Our Case Number: ABP-319866-24

Re: Proposed development known as North Irish Sea Array ("NISA") Offshore Wind Farm
Located off the coast of Counties Dublin, Meath and Louth (www.northirishsearraysid.ie)

Re: Application No. OA29N.319866
North Irish Sea Array Wind Farm Ltd
North Irish Sea Wind Turbines

VP24 (View 1) Baseline Photo and Wireline  
Amenity Area Skerries (Fingal),  
Co. Dublin

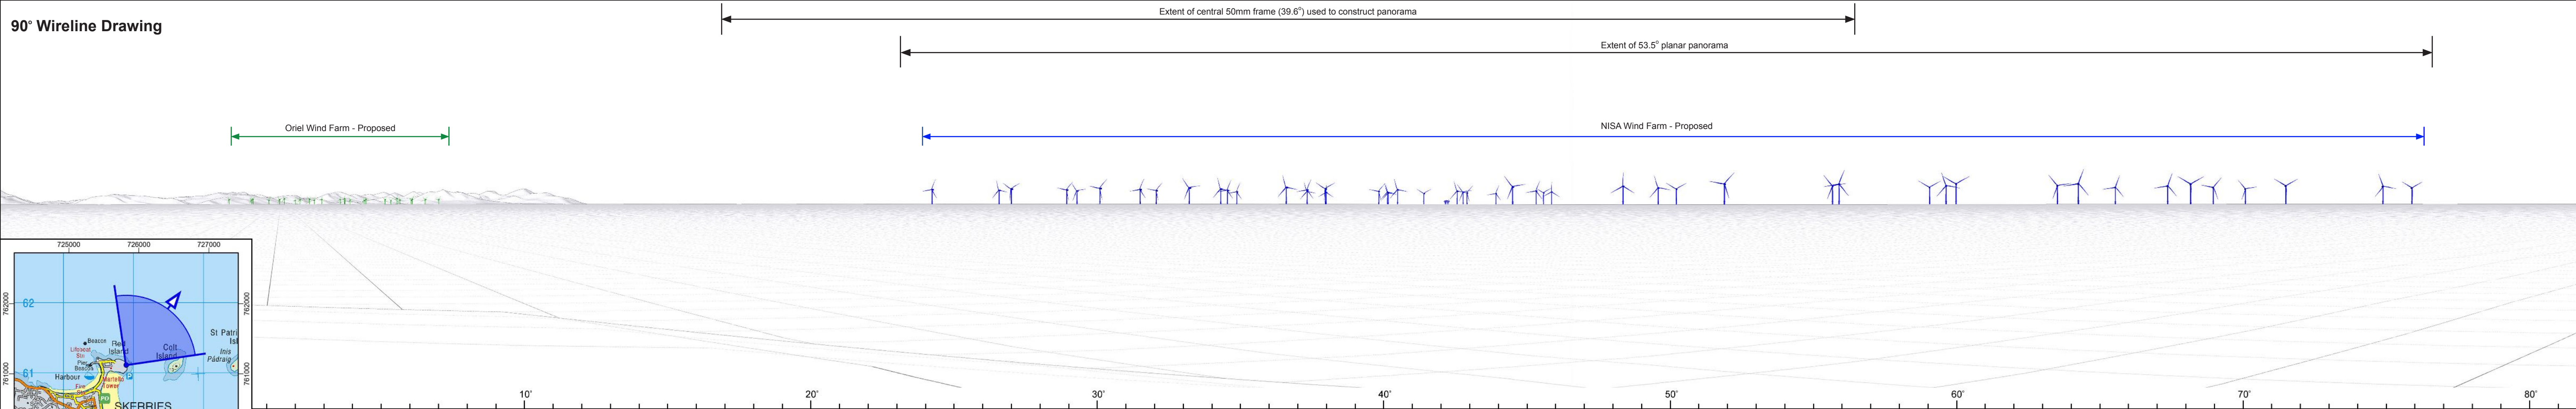
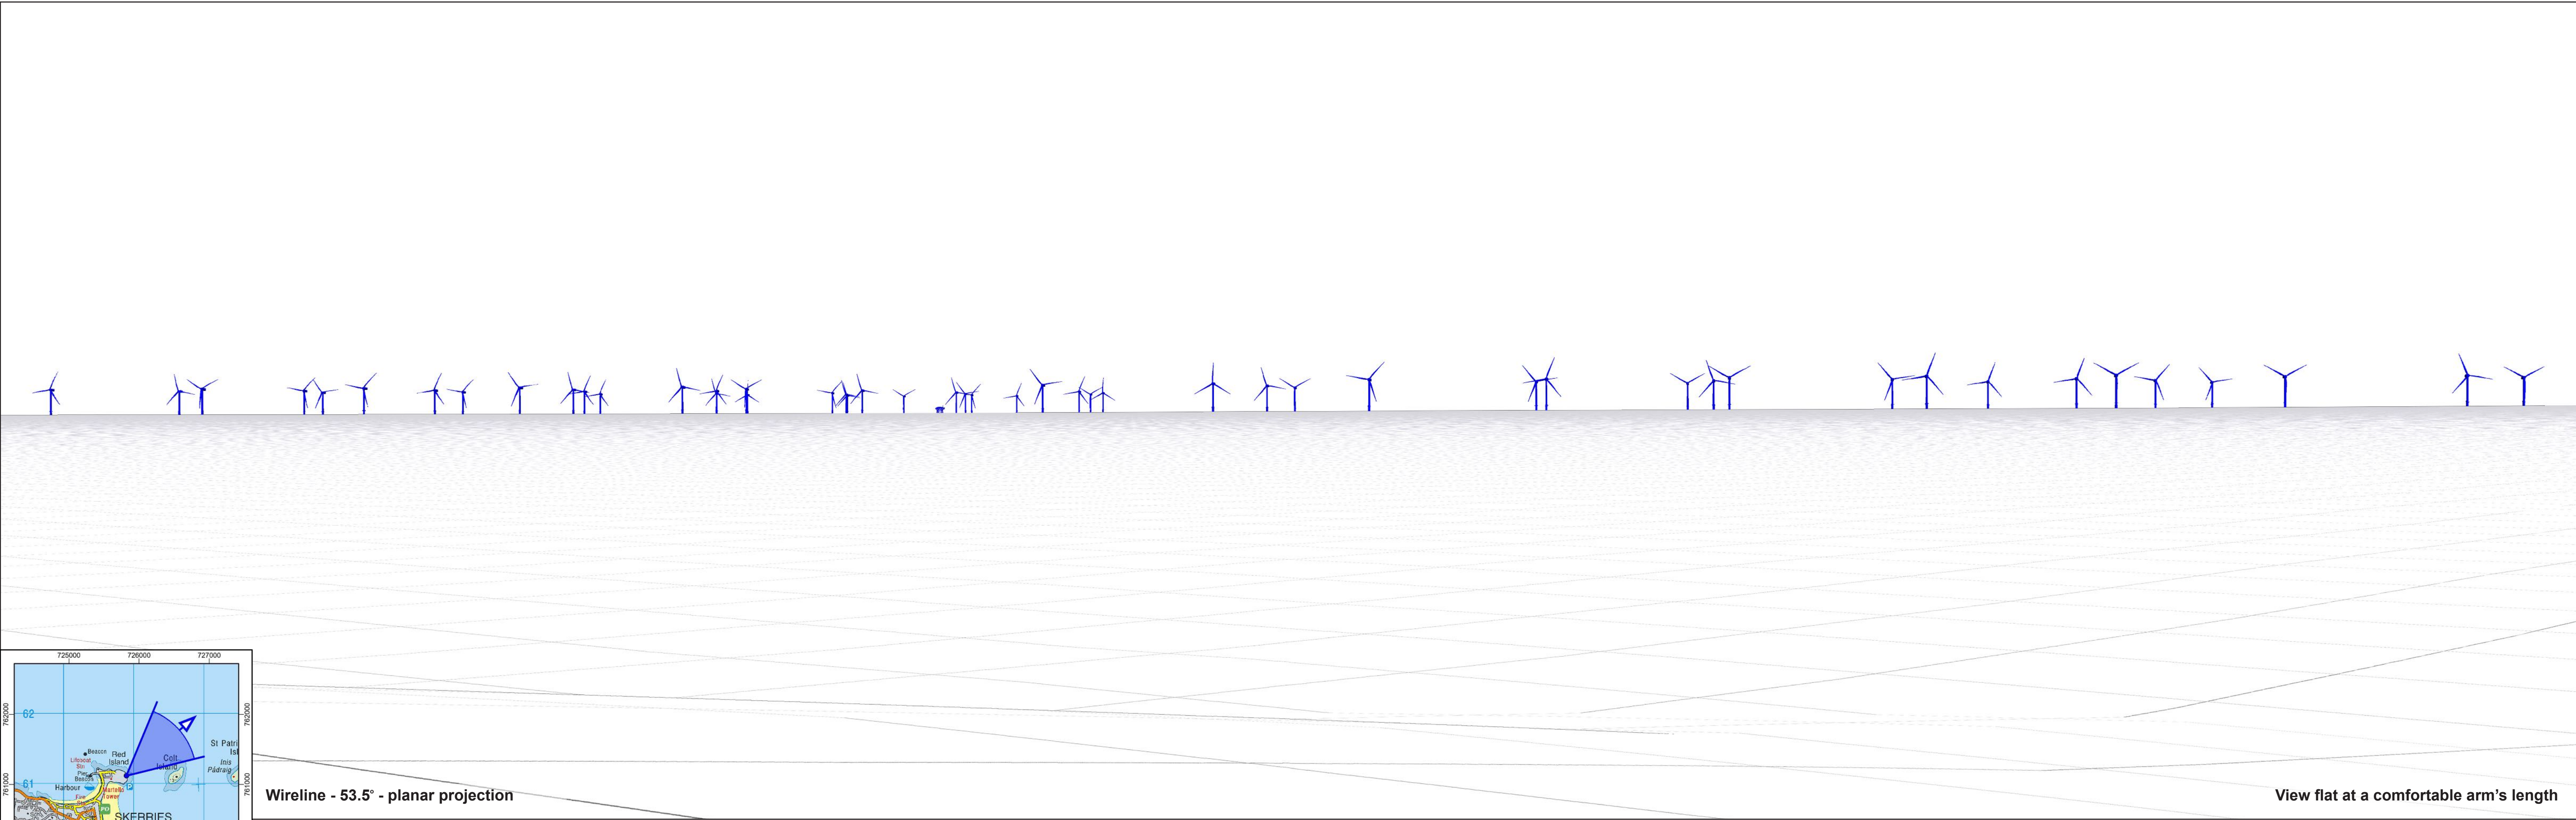
2. Nor will they be sited far from our shorelines and will be clearly visible from Drogheda Bay and Baltray to Skerries, even to Howth. Please note that the coast line from Mornington to Gormanston has been named the Gold Coast by Meath Co Councilt because of its beaches and beauty but these gigantic "beauties" will uglify the view for the thousands of people visiting and living here.
